District: Cherwell

Application No: 20/01164/DISC-2

Proposal: Discharge of condition 10 (Drainage) of 14/01932/OUT

Location: OS Parcel 7400 Adjoining And South Of, Salt Way, Banbury

ATTENUATION BASIN A SECTION  
SCALE 1:250

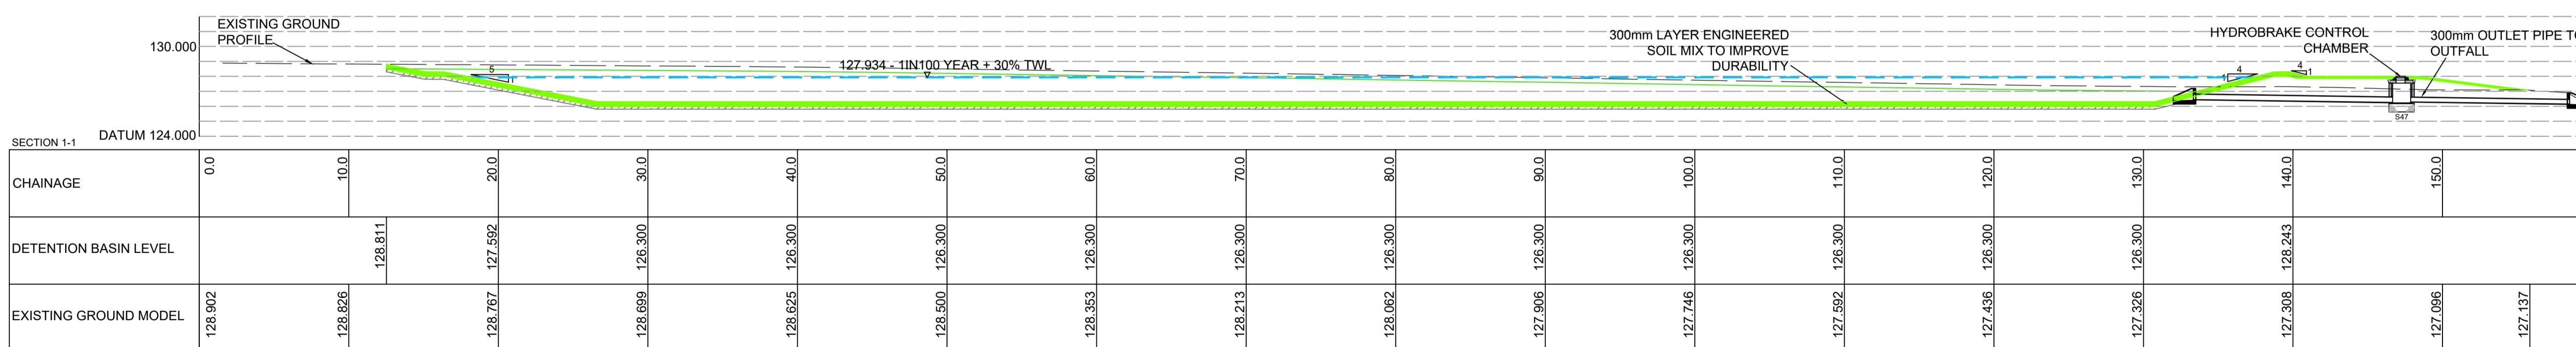
The top water level during the 100y+40%cc event at the flow control chamber/attenuation basin is 122.685, however the lowest top of bank level at the pond appears to be 122.50mAOD, need clarification to ensure that a minimum of 300mm freeboard is being provided.
